Date: 02 December 2022
Our ref: 64091/03/SSL/PB/26068393v1

Land at Avondale Drive, Hayes – Application for a Non-Material Amendment to Planning Permission 76551/APP/2021/4502

This letter sets out the proposed amendments sought by this application and provides a short assessment of the changes against the provisions of S96A of the Town and Country Planning Act 1990. This application relates to the detailed element of the permission associated with phase 1A of the development.

Section Comparison

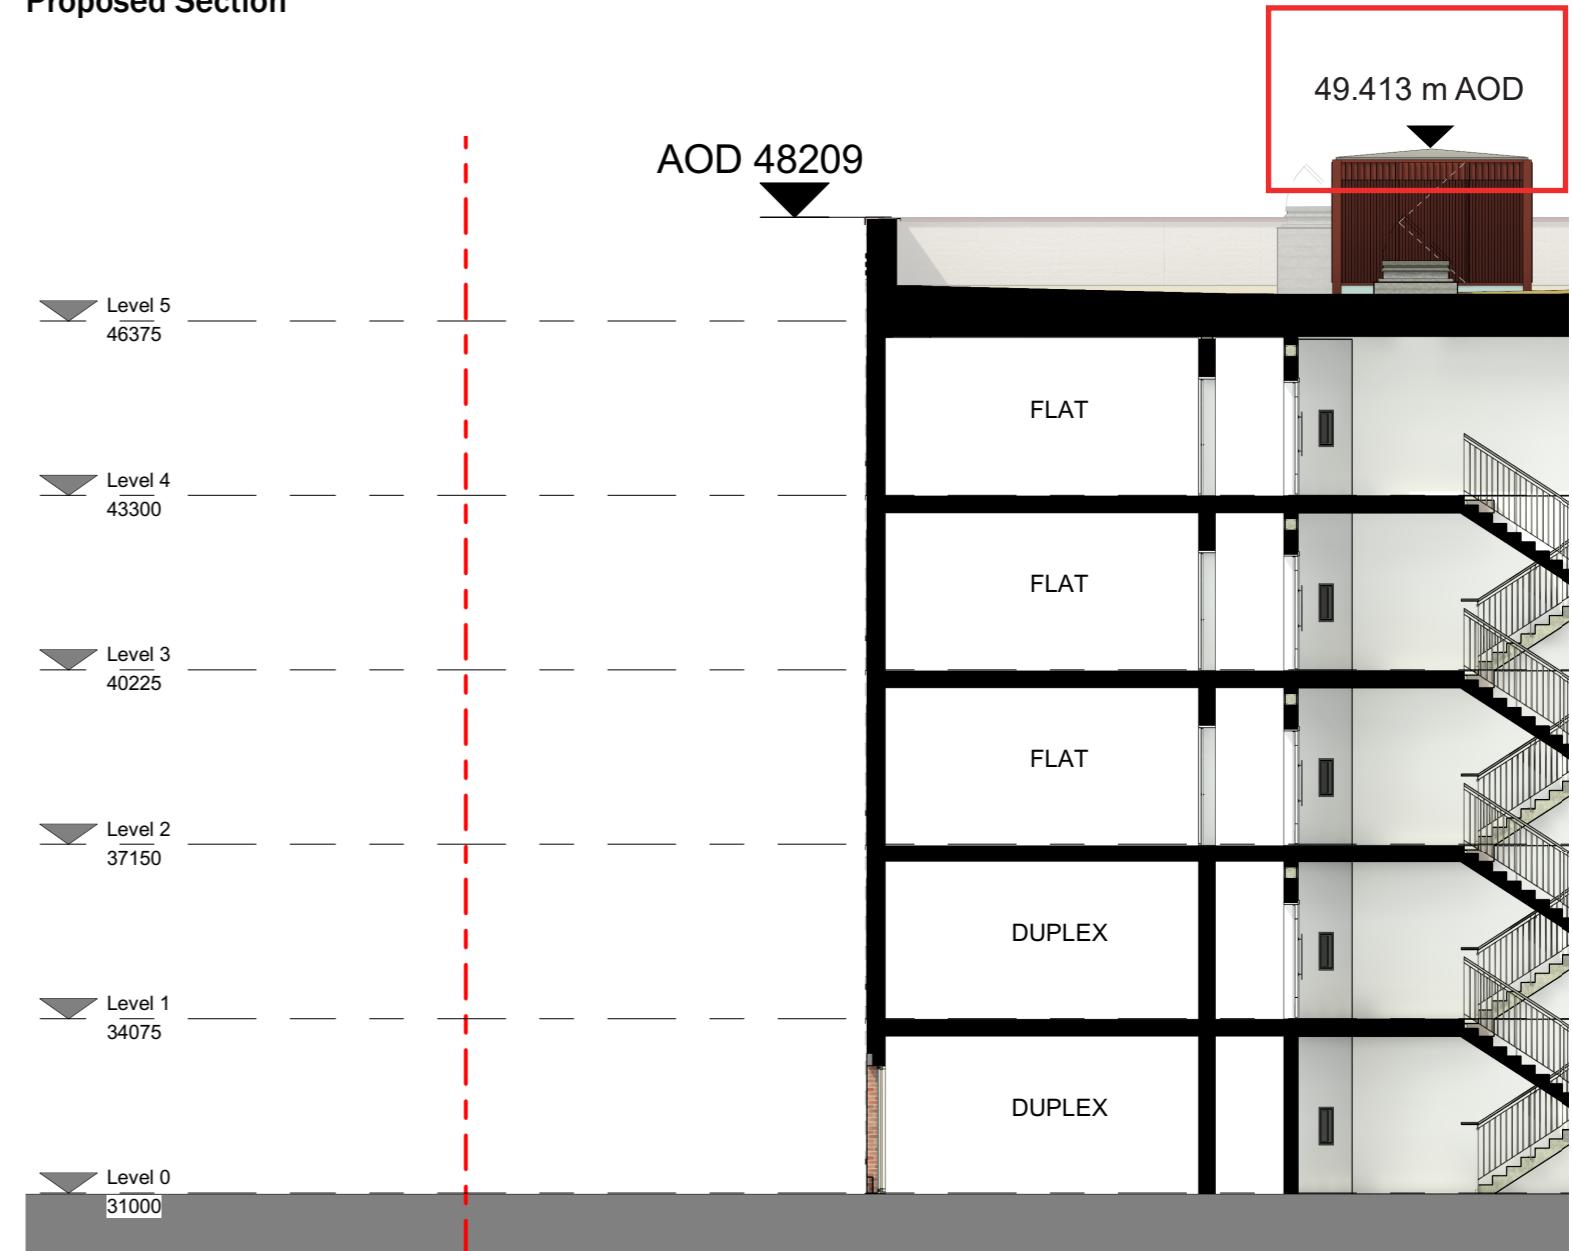
The amendments to the roof build up increases the overall AOD by 439 mm from the permitted scheme, with no changes regarding the floor-to-floor height in the proposed dwellings. As demonstrated in the DAS Addendum (Section 4) this increase will not have a material impact on the massing or appearance of the proposed building.

Plan Comparison

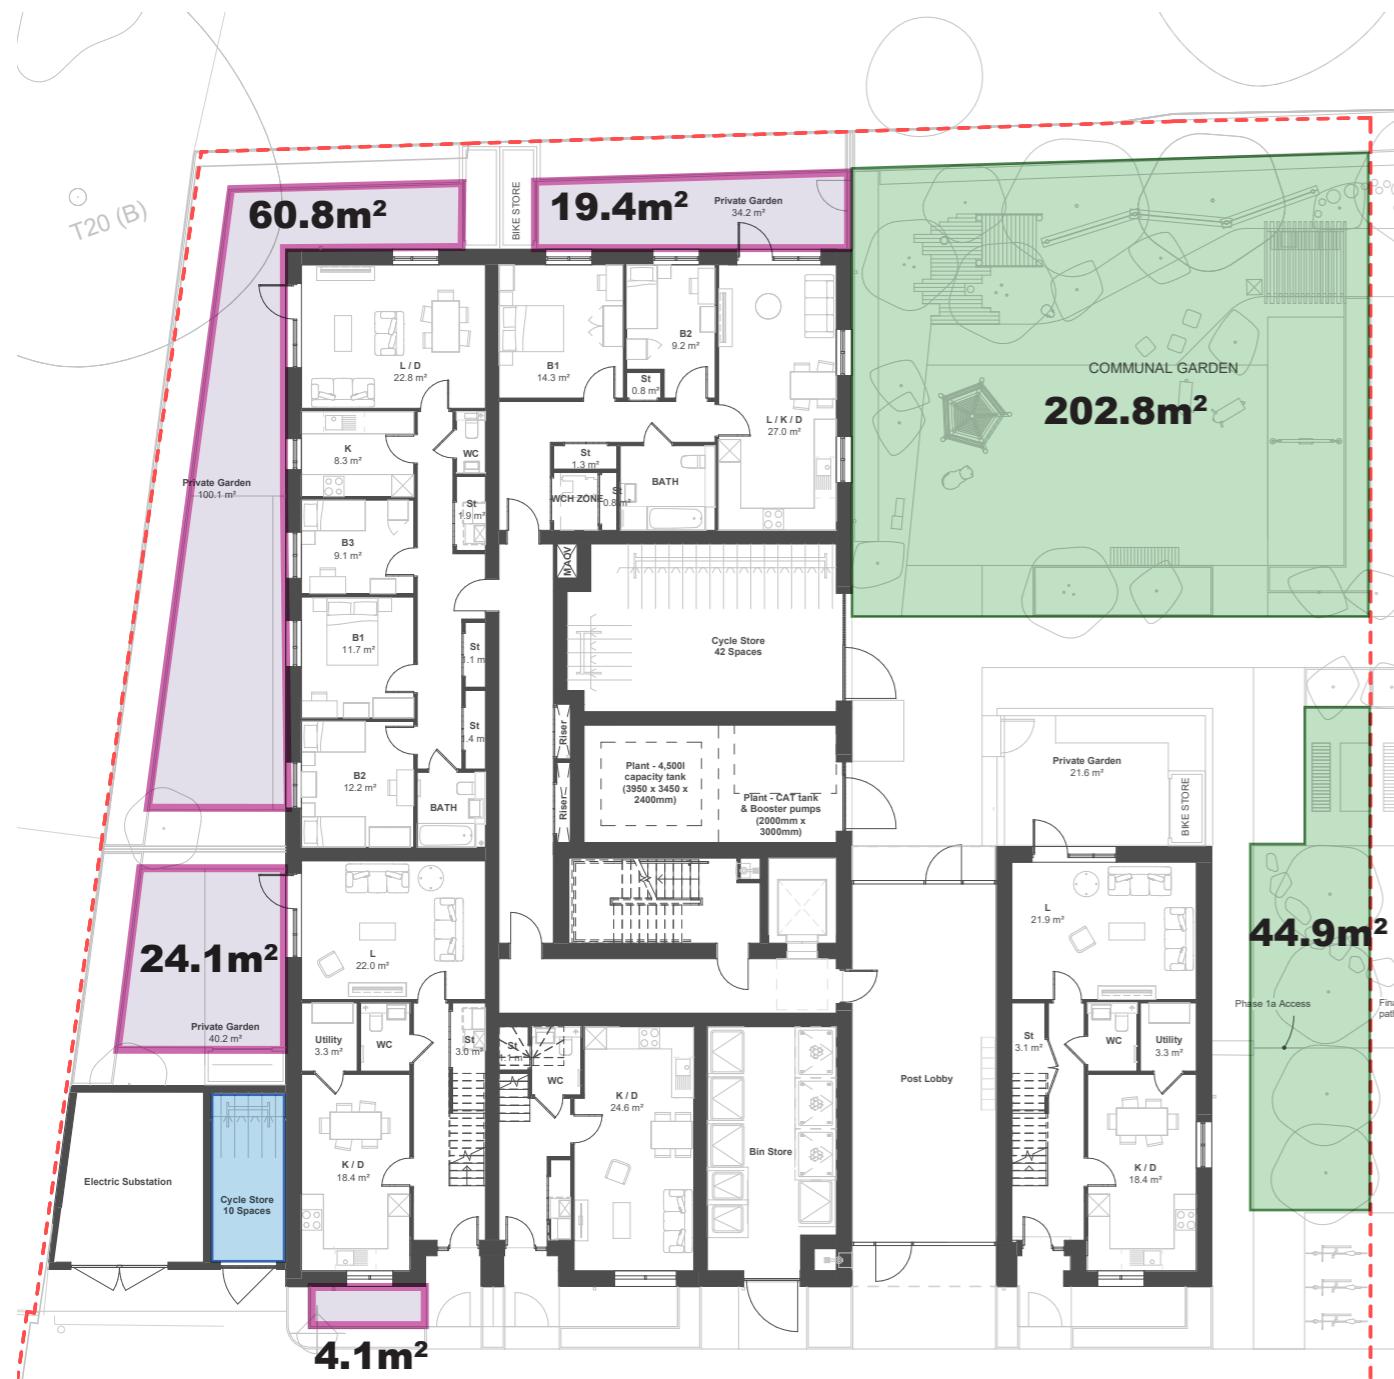
The alterations to the building footprint are proposed to allow additional space adjacent to the phase 2 block, permitting an enlarged proposed play area and increasing the separation distance with subsequent phases of development. Additionally, this allows the southern edge of the block to align with that of the proposed outline masterplan.

The proposed landscape plan is largely unaltered, however some materials, planting and general arrangements have been rationalised in detail including the following changes (see page 26 of DAS Addendum):

- Landscape layout to boundary refined to suit the shifted building location
- Seating area replaced with external cycle storage to accommodate the relocated cycle store
- Planting against building revised in consideration of maintenance and feasibility

Minor ground floor arrangements are proposed to improve operational efficiency and structural alignment, including relocating the approved cycle store adjacent to the substation. Small improvements to the dwelling layouts are also proposed to allow for utility cupboards of consistent dimensions for efficiency in servicing, refinements to the quality of accommodation and to reflect small changes in tenure due to an updated understanding of the number of returning leaseholders (to be addressed via a subsequent deed of variation). For the avoidance of doubt, the same number and type of dwellings are proposed. The single cat M4(3) unit remains where it is in the consented scheme and
